13 December 2015

Re: SCECGS Redlands School Concept Proposal and Stage 1 Development; SSD 6454.

NEW HUMPHERY LEARNING HUB - STAGE 4

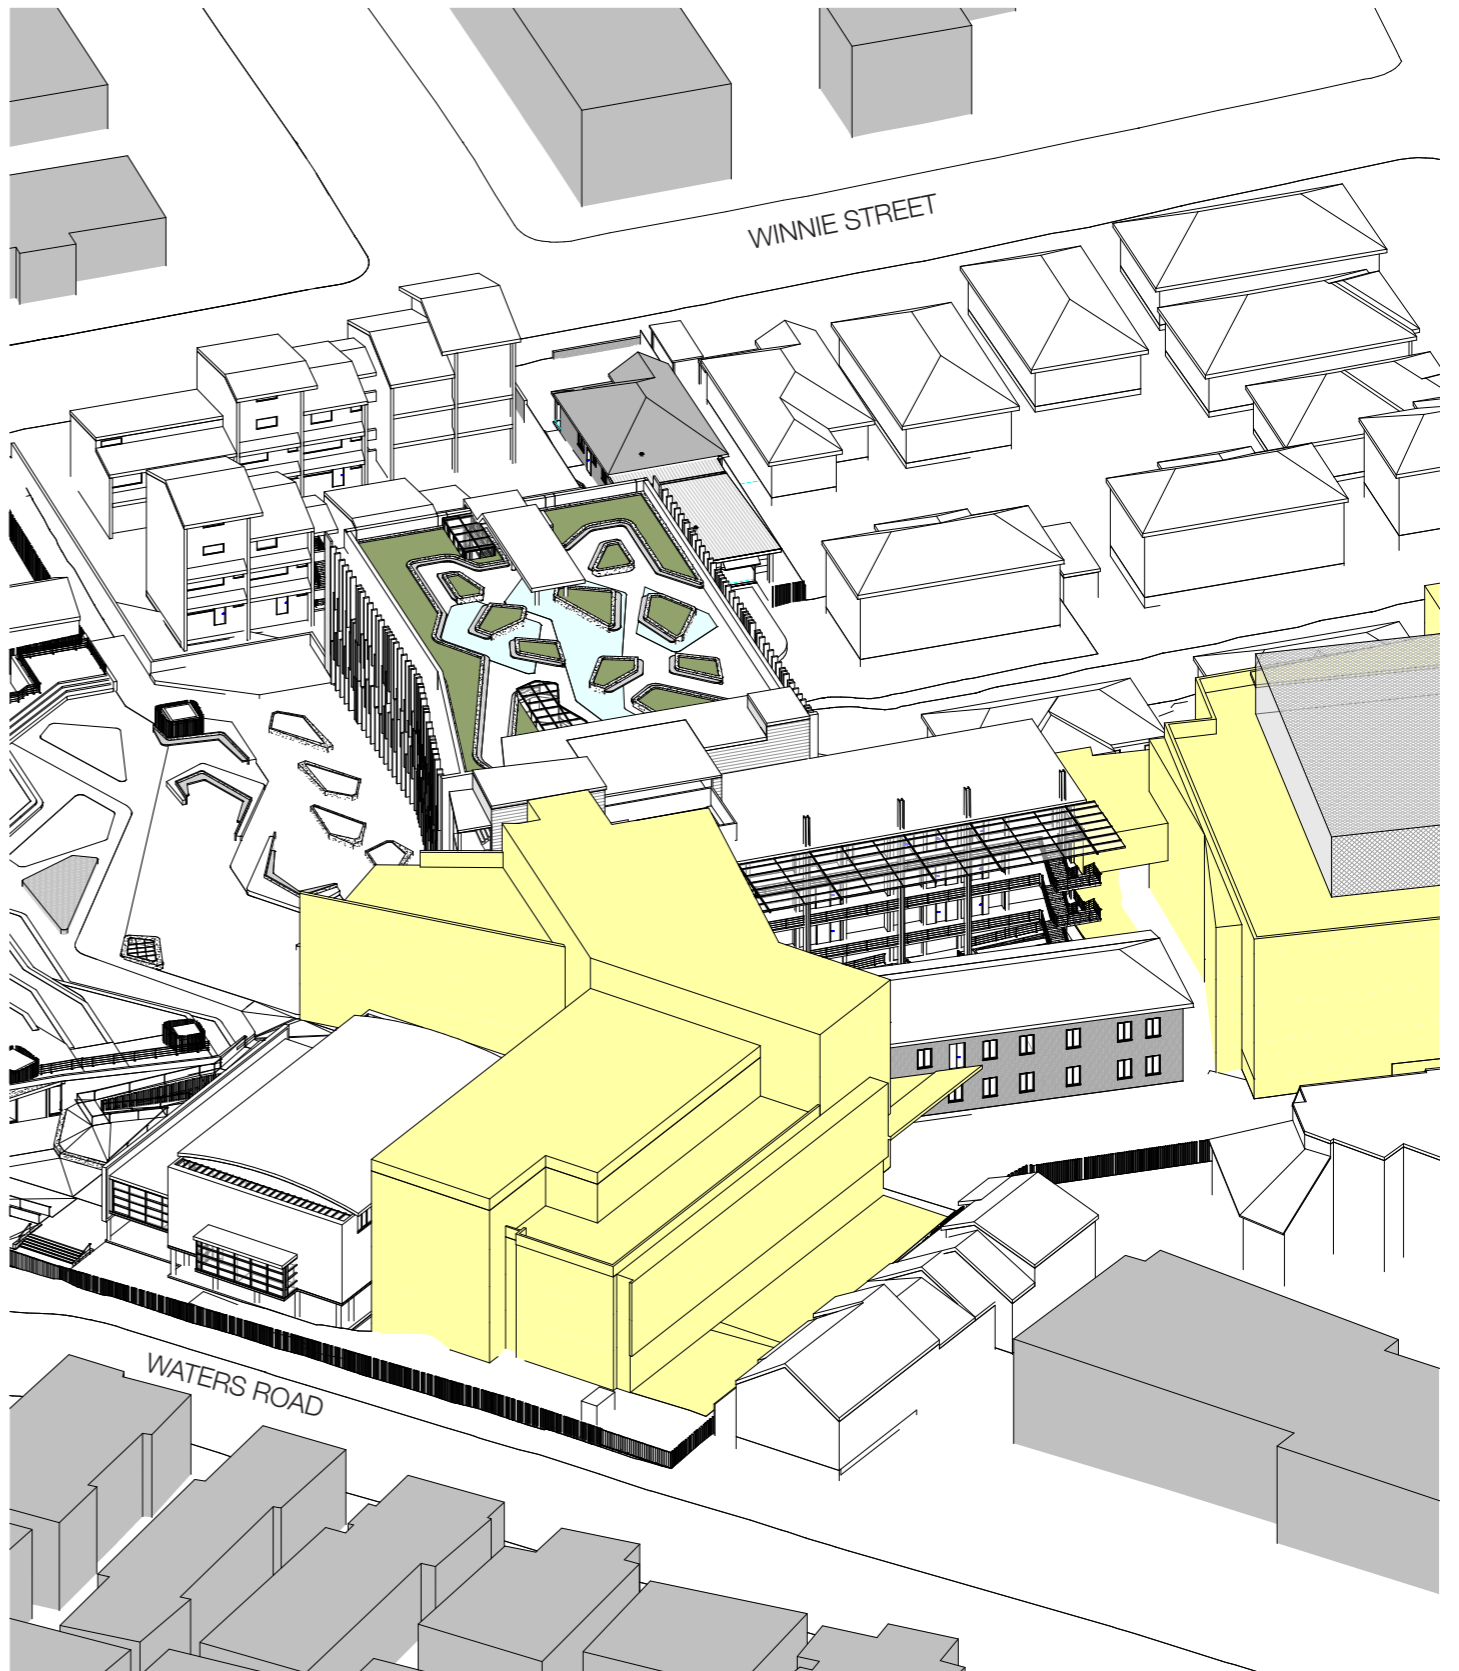
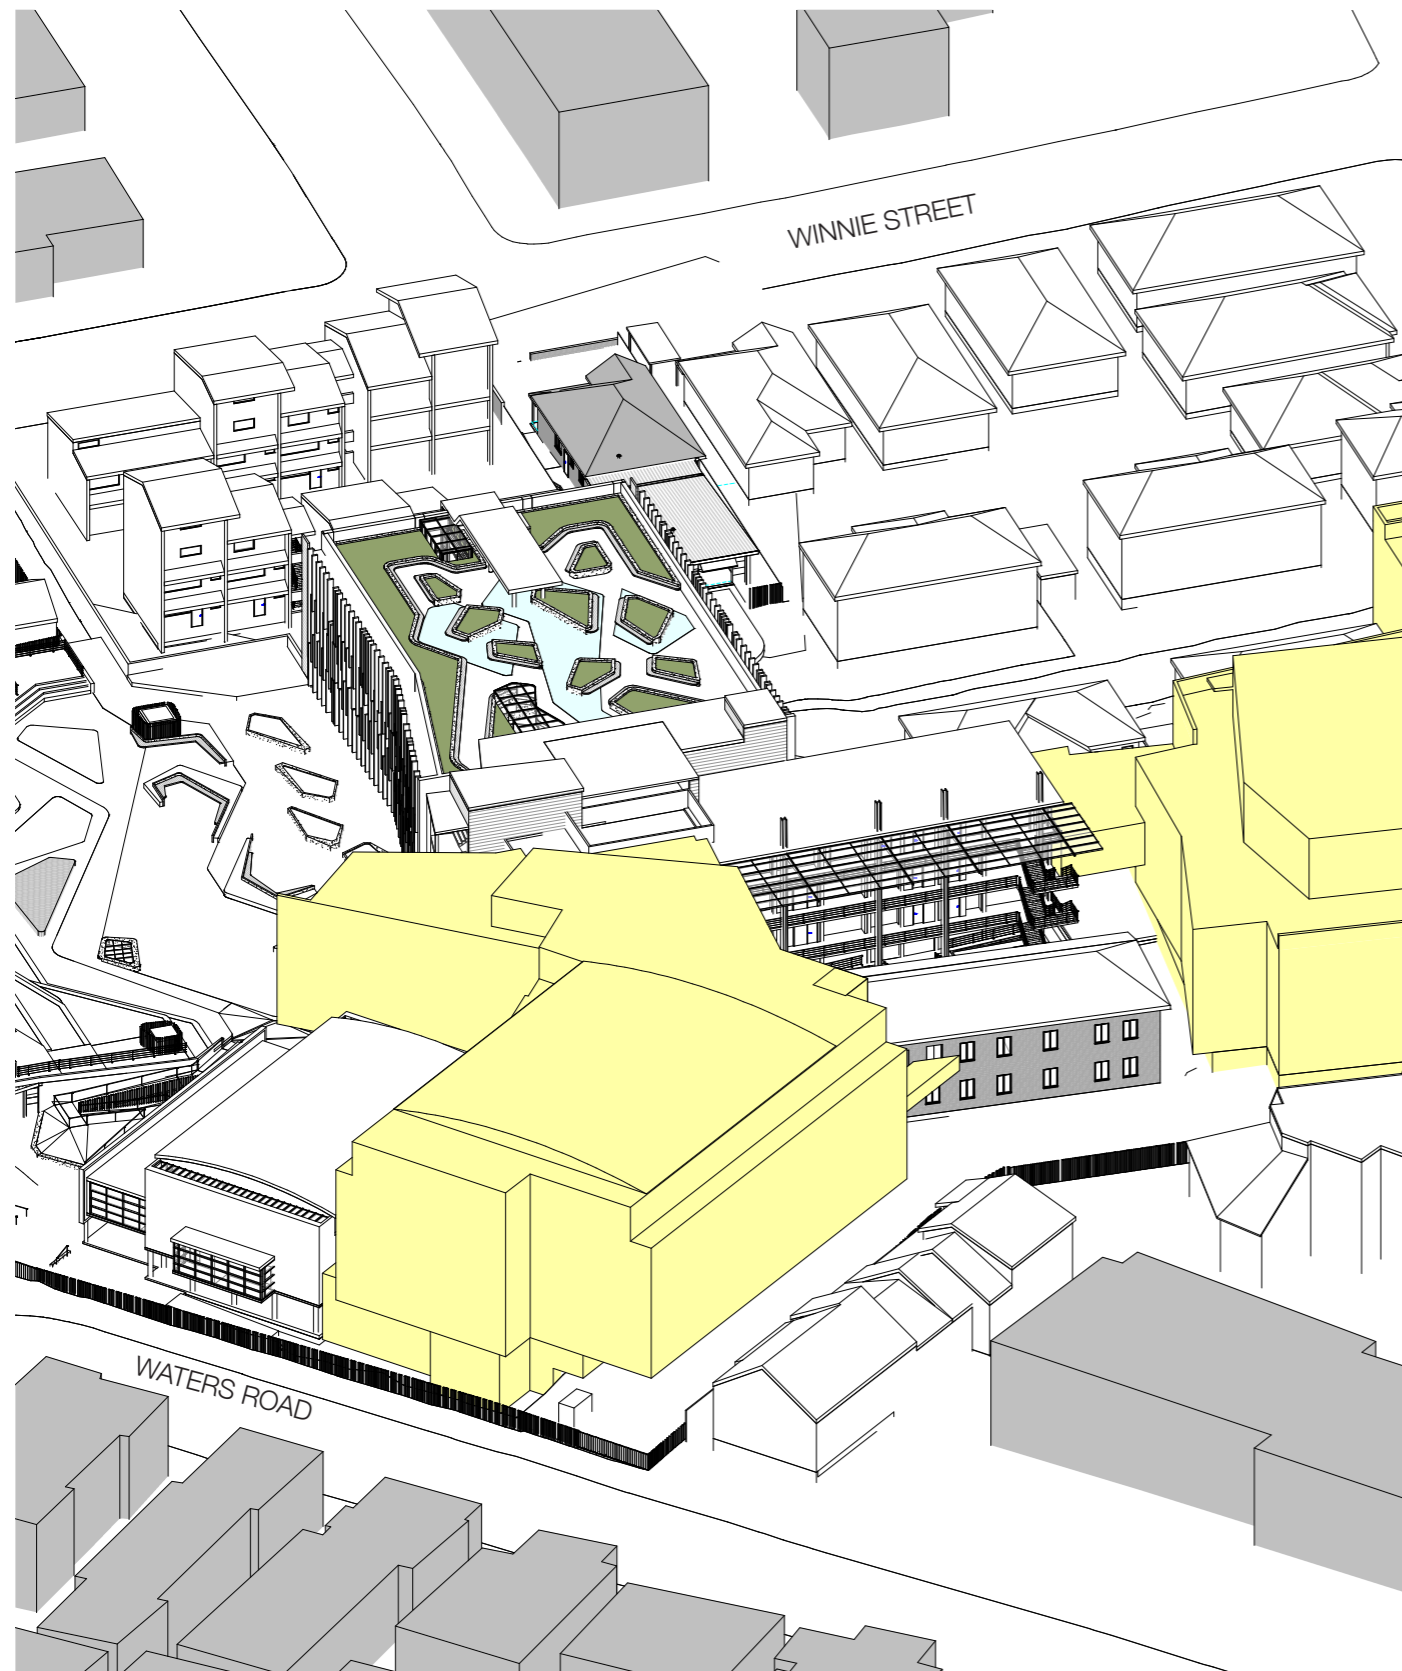
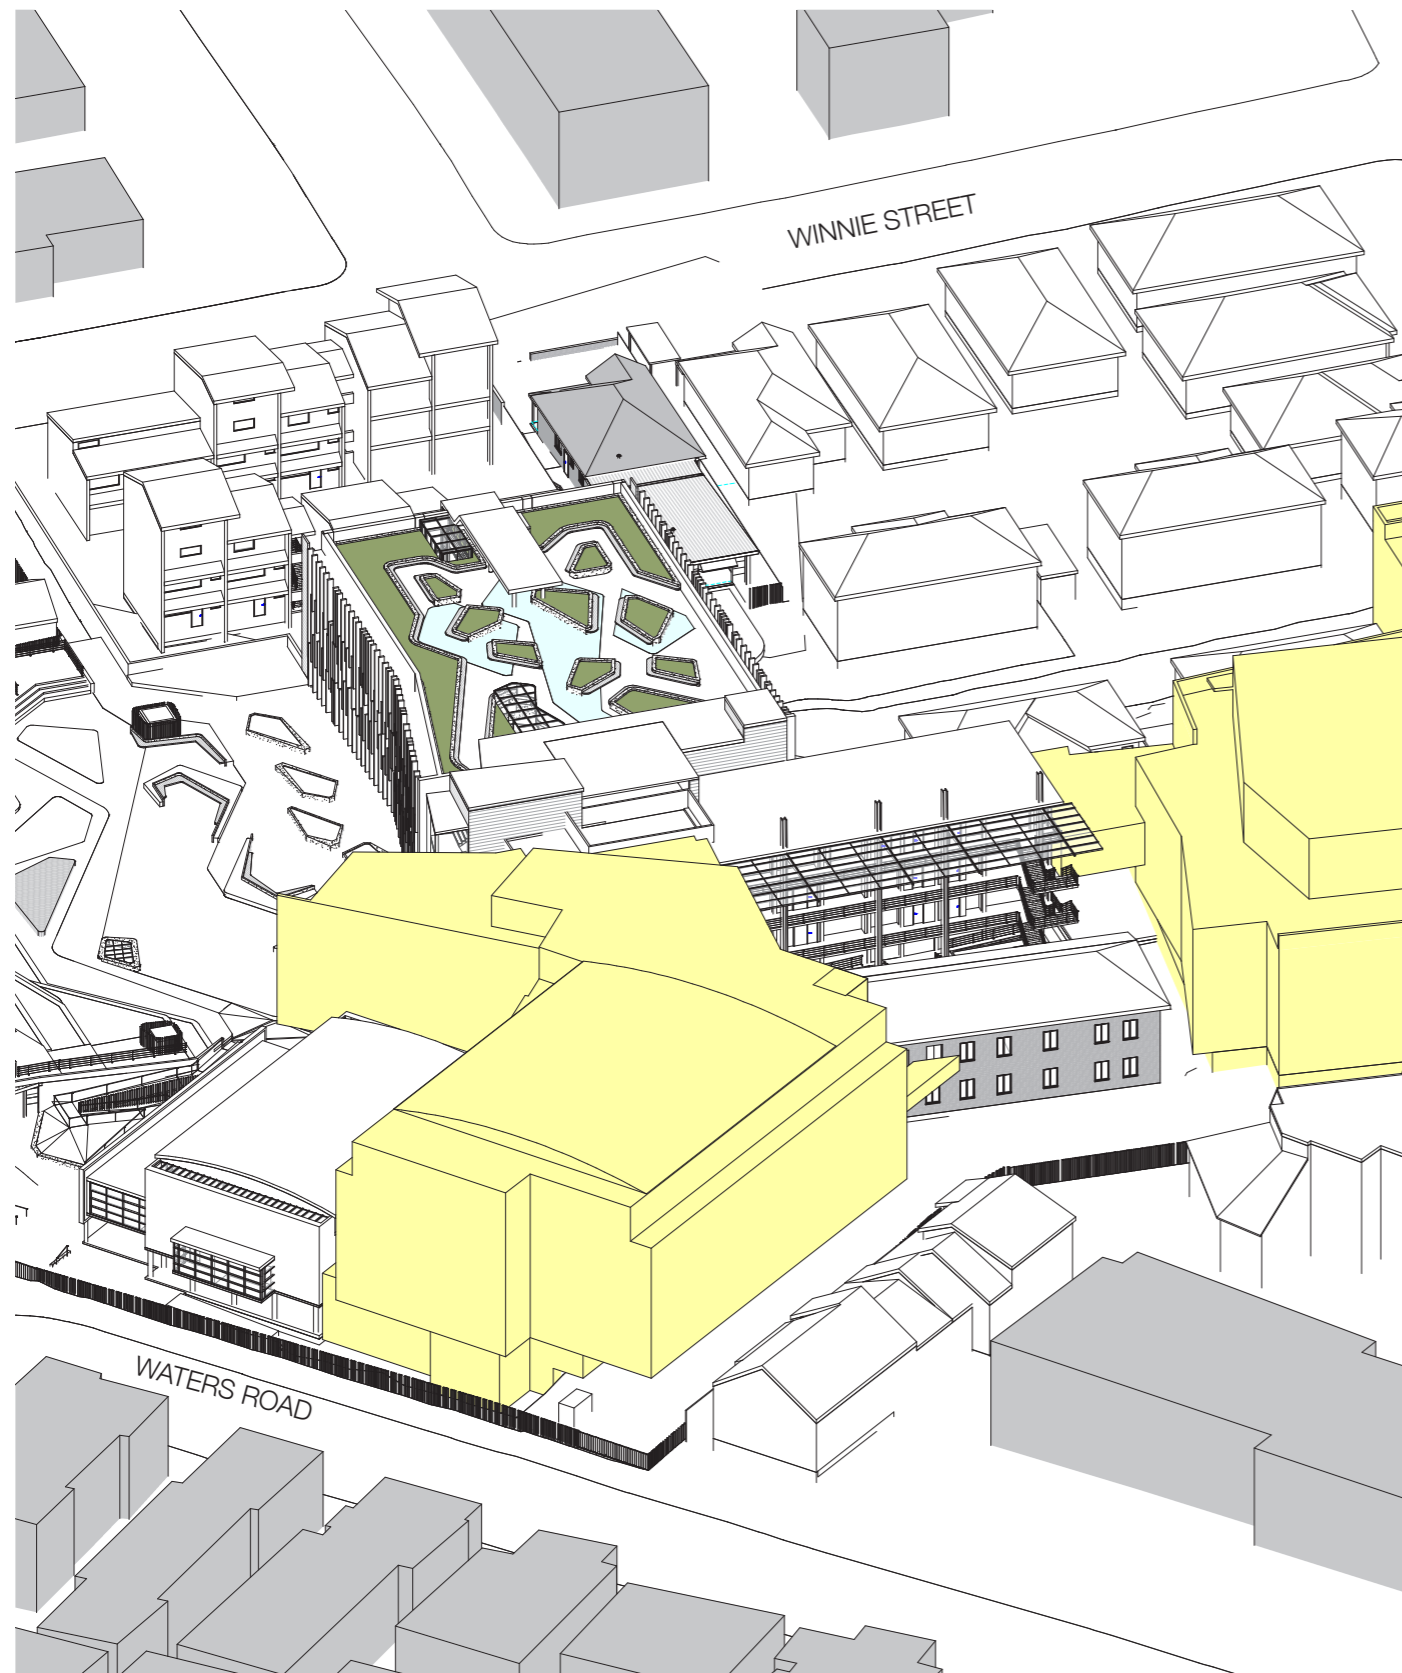
The proposed Humphrey Building has been reduced, though it is still non-compliant with North Sydney Council height restrictions. It is 22.55 metres high, in an area that has a 12 metre height limit – this is approximately 87% too high. I find the requests for the height exemption to be weak. I oppose the school being allowed non-compliance just so it can “develop the facilities required by the School on a single site” (in other words – just to conduct its business). There are higher buildings nearby, but they lack a neighbouring proximity to the school. Further, we can achieve “improvements to the physical appearance of the site through a carefully designed building that is responsive to site context and its intended function” whilst maintaining compliance. I also question that reducing the scale of the development would “undermine the visual quality of the design” - I would expect visual quality of a design can be maintained regardless of scale. Finally, if non-compliance is the only means by which the school’s “accommodation requirements” can be met, then a review of those requirements should be undertaken.

The swimming pool of the Humphrey Building has been moved to the basement of that building. Noise will continue to emanate from the basement when the pool is being used. I have reservations about the enclosure being able to suppress all generated noise associated with pool operation such as sports whistles and spectators. That usage will include training sessions that commence at 6am or earlier, along with carnivals that will occur on weekends.
